From: Amanda Scholes on behalf of Planning.Responses
Sent: 06 December 2019 09:09
To: Planning Scanning
Subject: FW: A/100/19/PL - Arundel Acre - response to Highways England and WSCC

From: Joney Ramirez [REDACTED]
Sent: 05 December 2019 15:13
To: Karl Roberts [REDACTED]
Cc: Nick Laister [REDACTED]; nic burrell [REDACTED]
Subject: RE: A/100/19/PL - Arundel Acre - response to Highways England and WSCC
Importance: High

Following the responses from Highways England and WSCC (dated 04/12/2019 and 02/12/2019 respectively) we would like to respond as follows:

RPS Drawing/Figure Number	Rev
JNY10317/01a	-

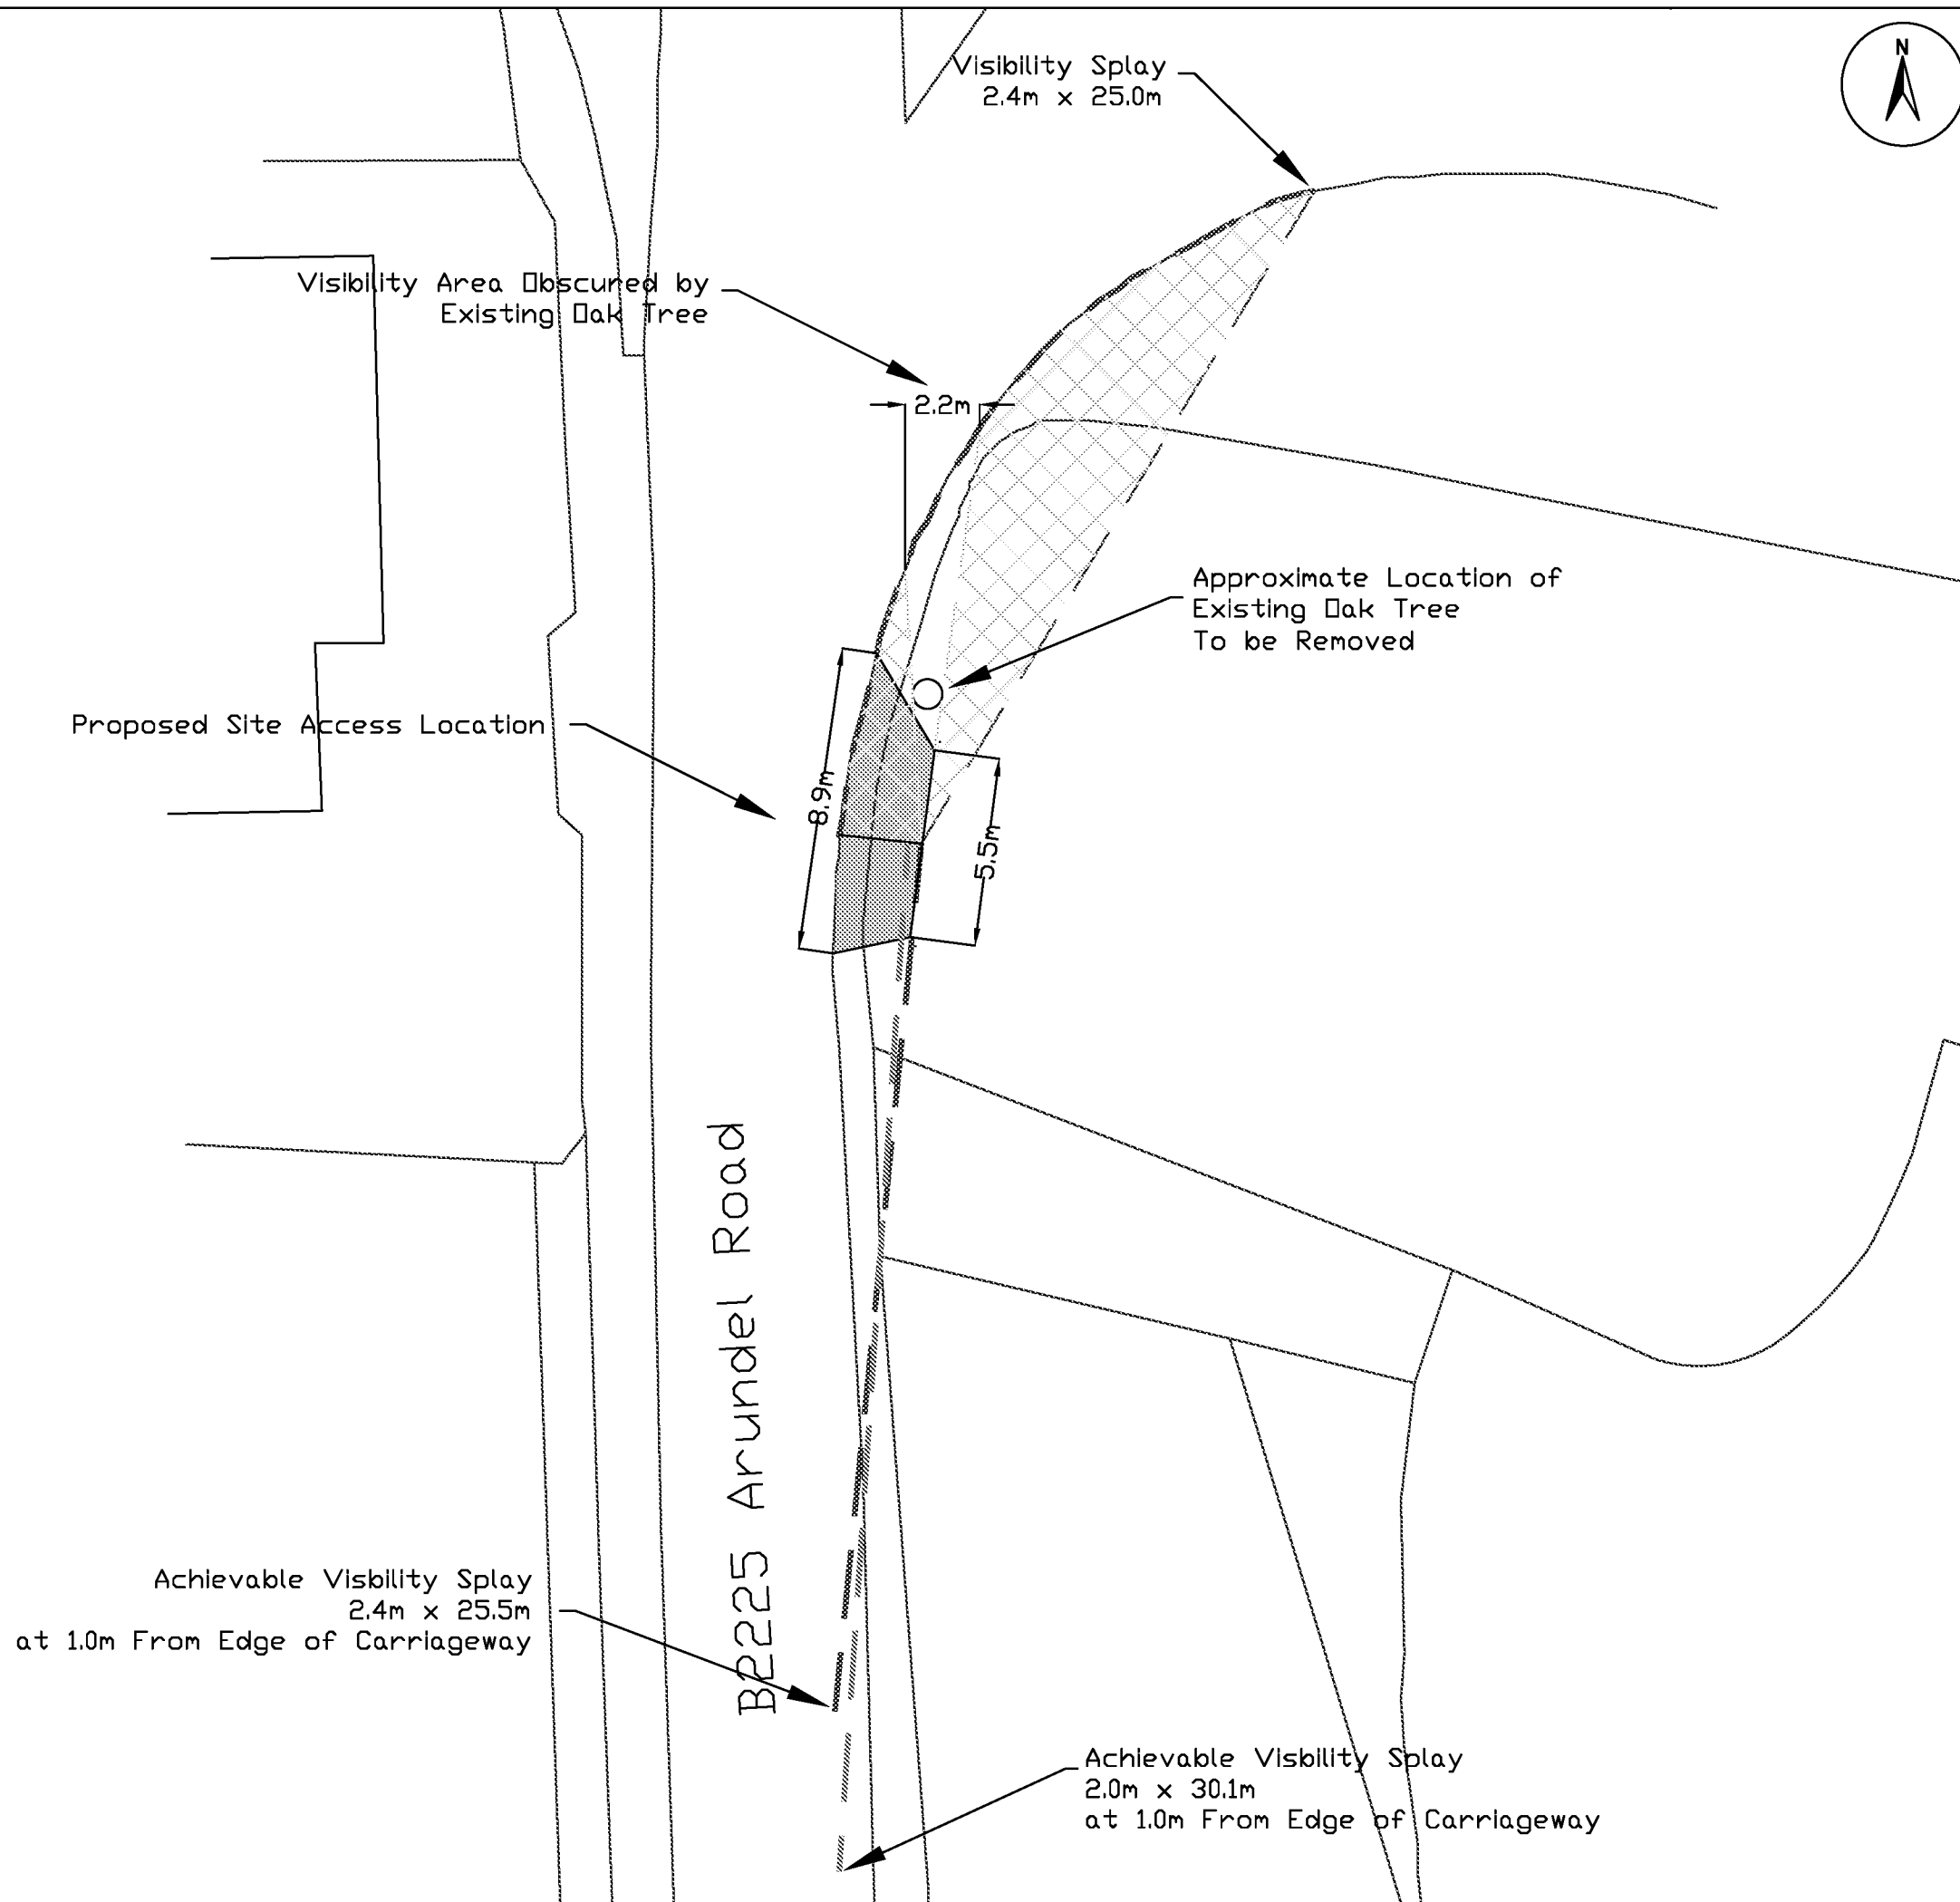
- ii. **The block plan is not representative of the road layout and the deceleration lane would result in higher speeds approaching the access point** – Submitted drawing No. JNY10317/01a is based on OS mapping and accurately shows the road layout. Although lane delimitation is not shown, the submitted ATC, plans and supporting documents provide, in our view, an appropriate level of detail to allow the LHA to assess the proposal, with the ATC providing specific detail regarding speeds.
